From: Jonathan Best <Jonathan.Best@arun.gov.uk>
Sent: 24 September 2026 13:59
To: Planning.Responses <Planning.Responses@arun.gov.uk>
Cc: Hannah Kersley <Hannah.Kersley@arun.gov.uk>
Subject: LU/250/25/RES

Local Centre and Phase 6b Hampton Park Littlehampton.

I have reviewed this application with regards to ecology.

scheme: Hampton Park
Littlehampton
client: Persimmon Thames Valley
drawing: Soft Landscape Proposals
Local Centre
date: November 2025
scale: 1:200@A1 Sheet 1 of 5
drawing no: PERTV248071
drawn: RH checked: DKM

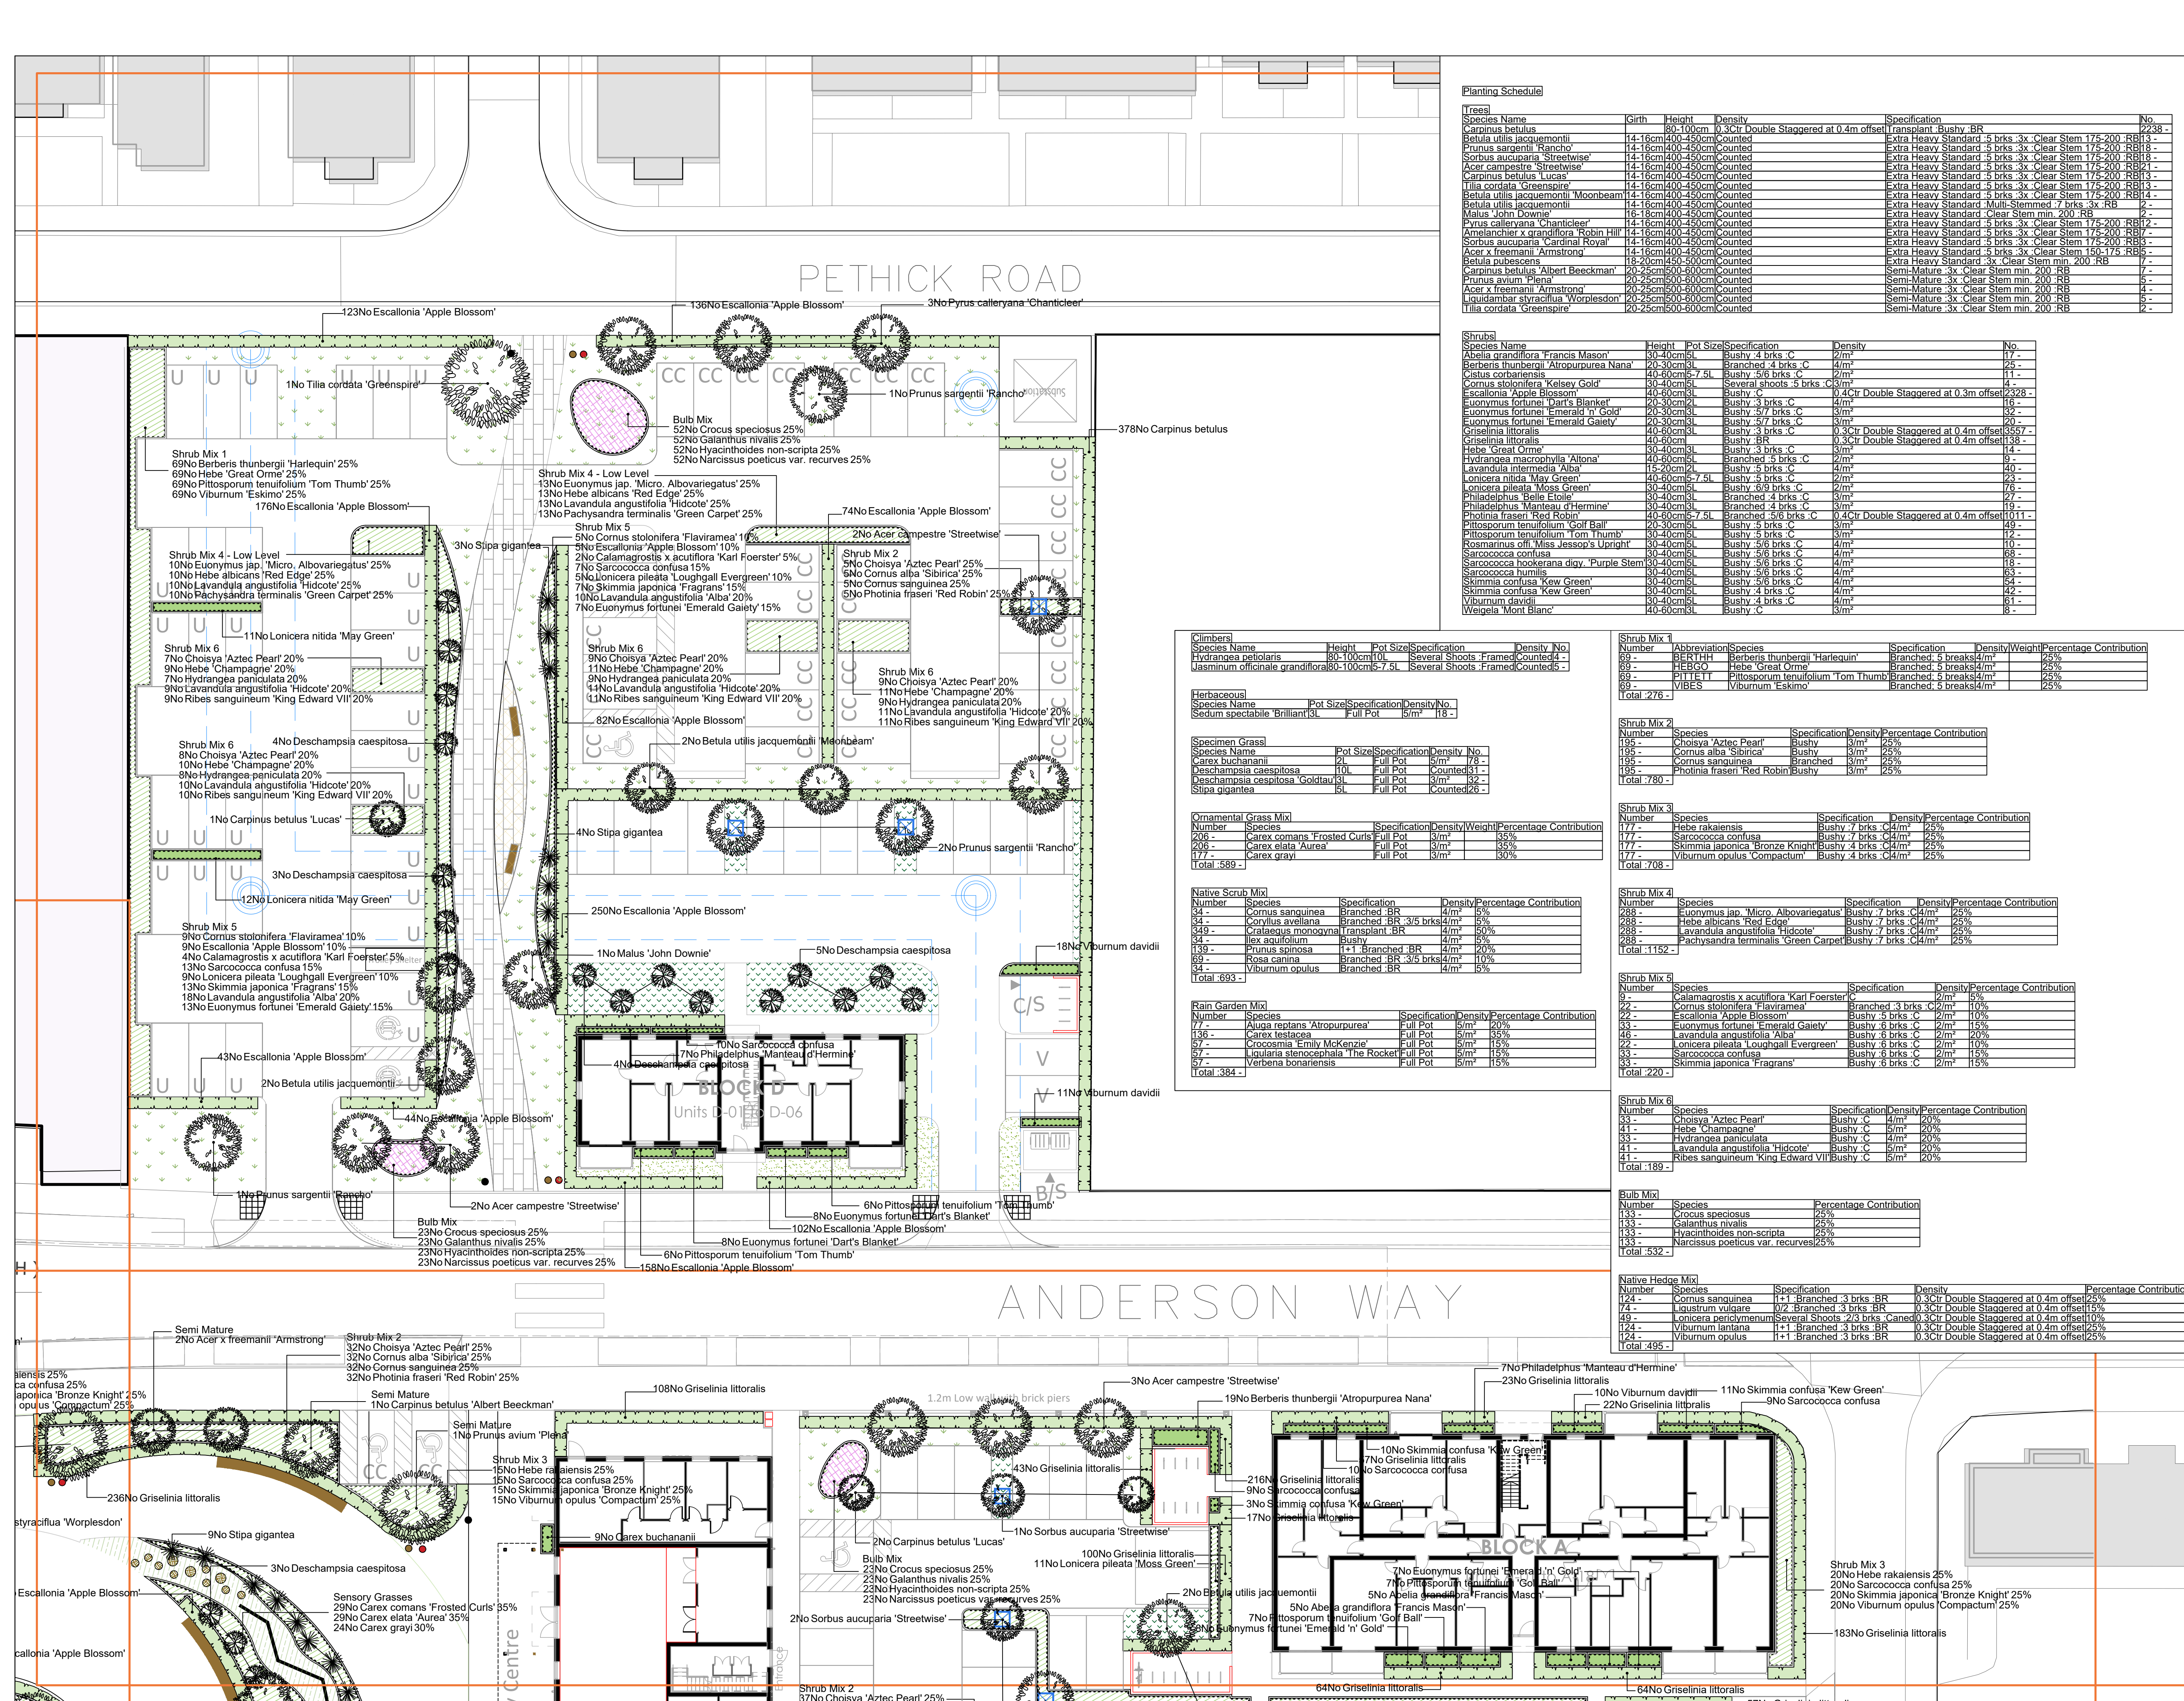
The proposed planting for the LEAP and the housing is acceptable with regards to ecology. For the LEAP the native hedge should be planted at least one metre away from the fencing because several of the hedging plants have thorns and could become a hazard to children.

**Map 2 - Ecological Mitigation and  
Enhancement Plan**

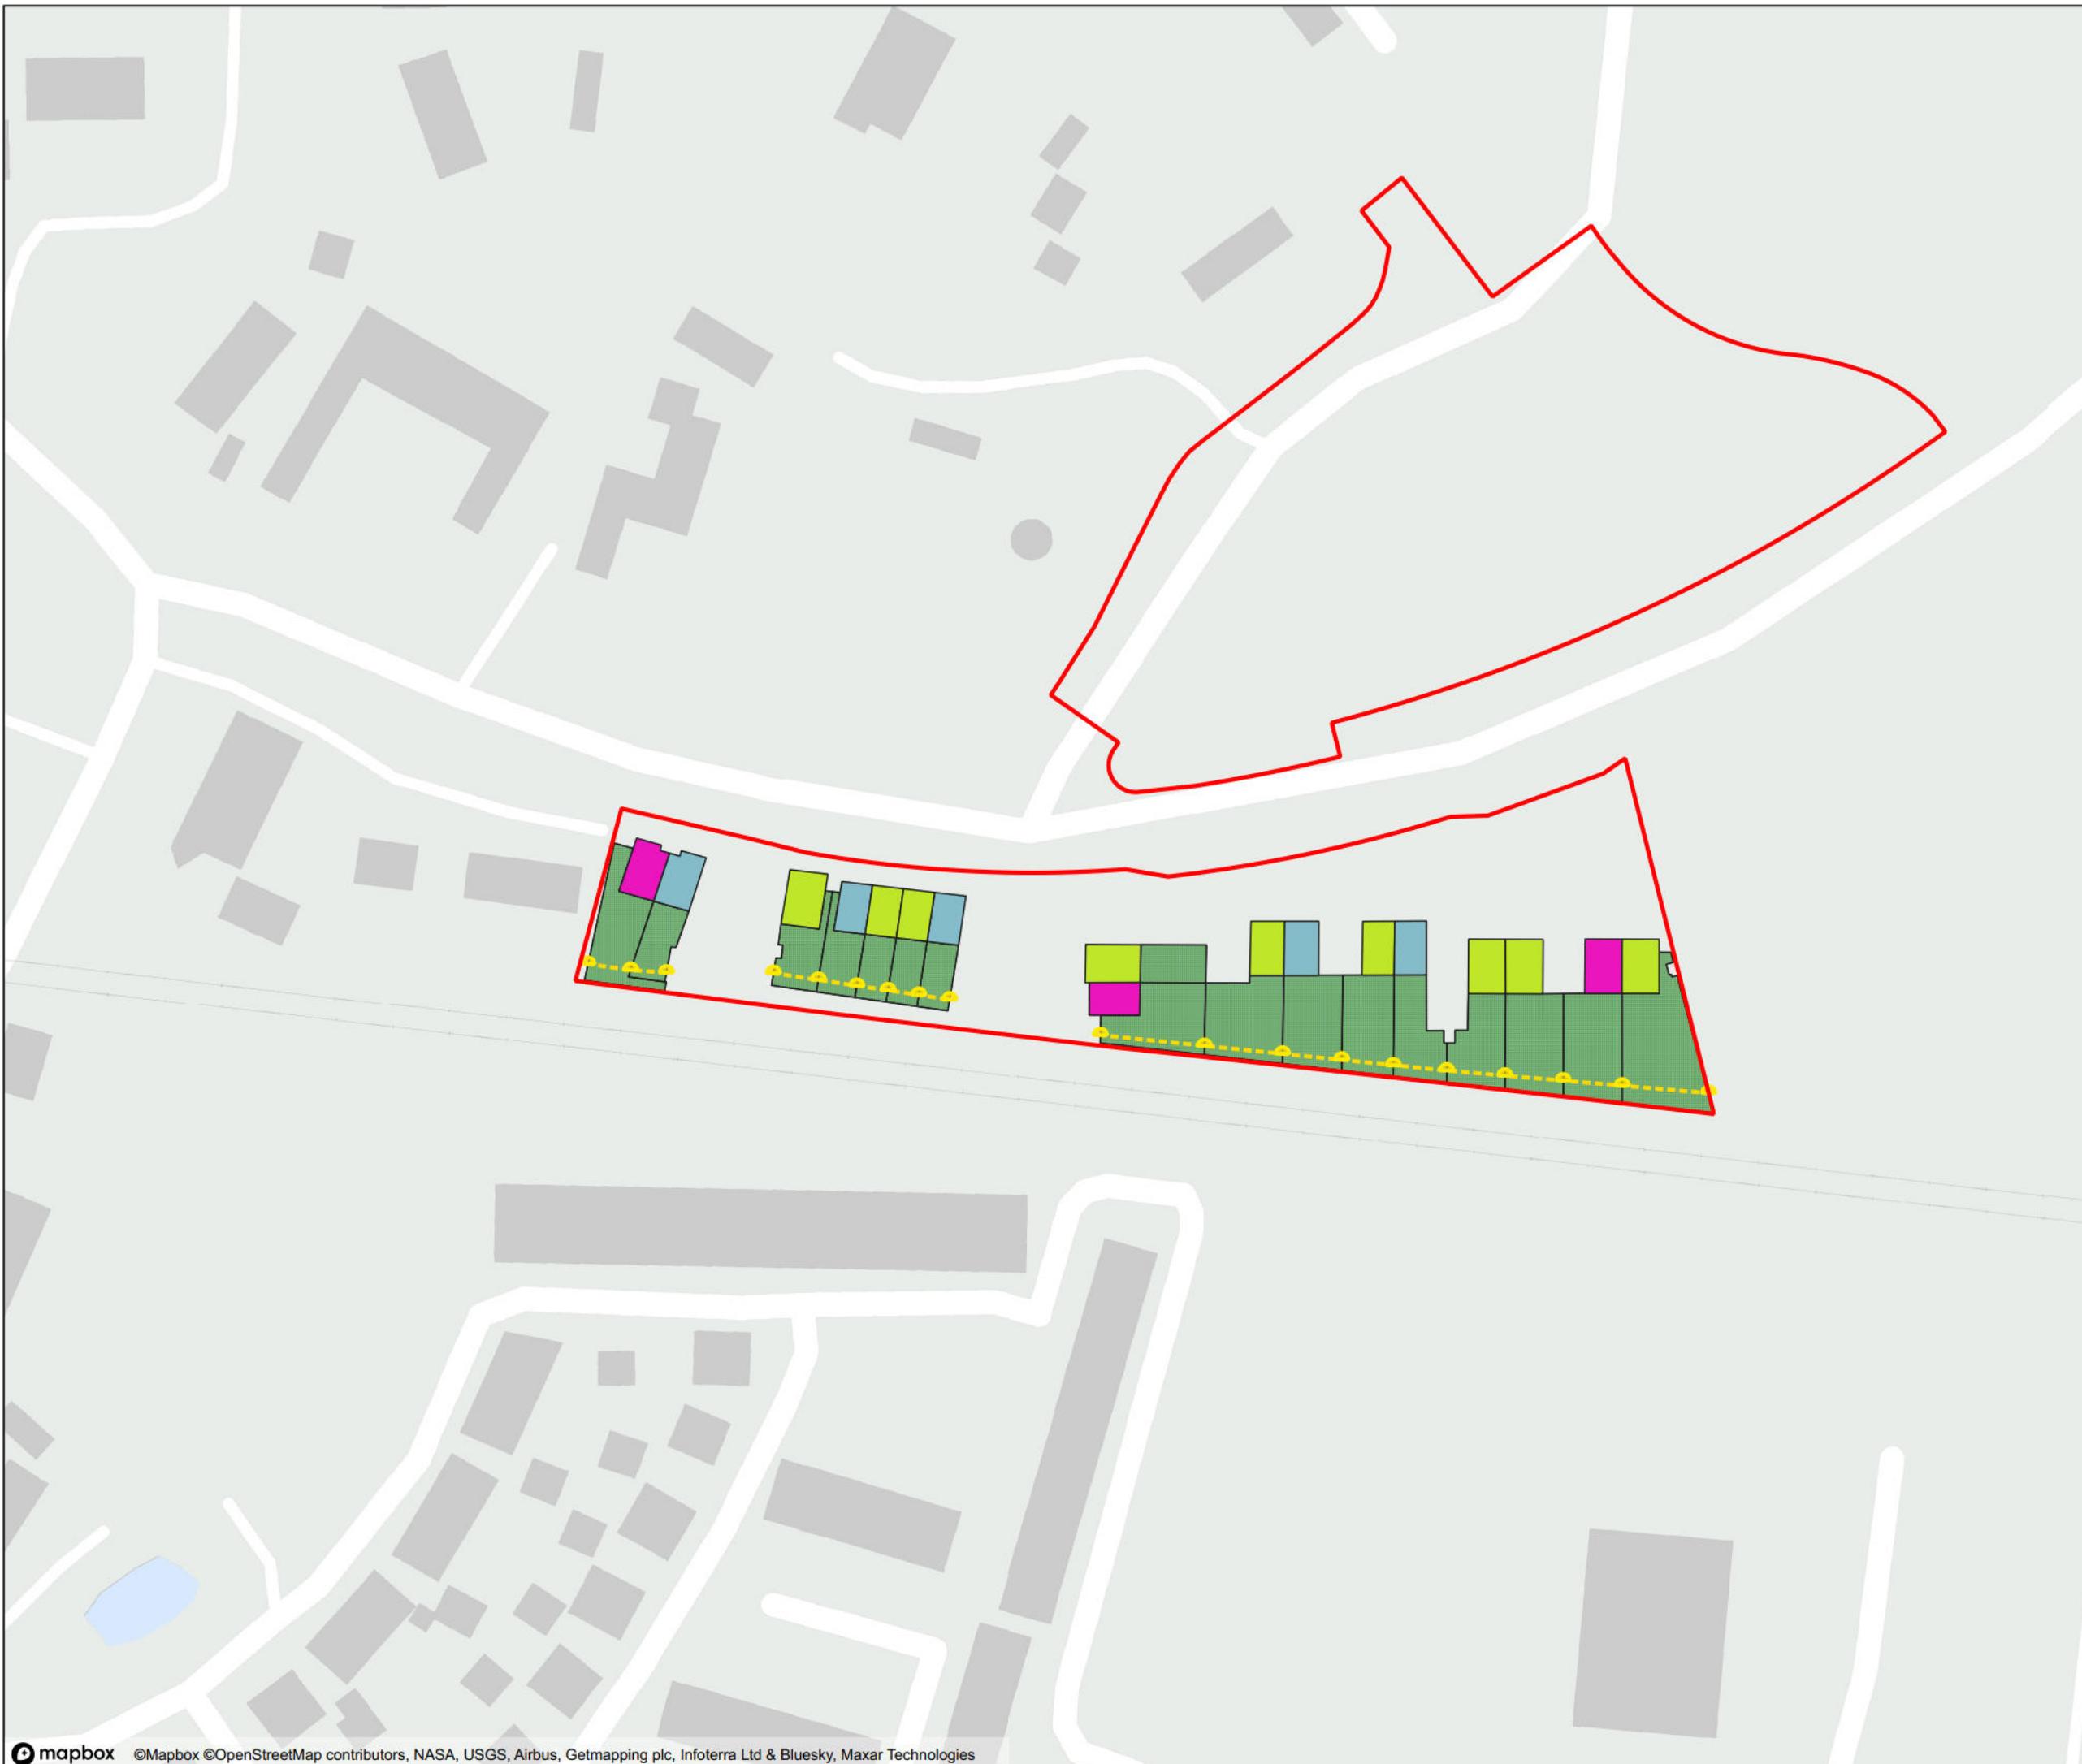
The EMMP shows hedgehog gaps between the gardens but access to the wider environment is restricted by the brick walls. Small mammal gaps should be installed in the walls to allow movement of hedgehogs.
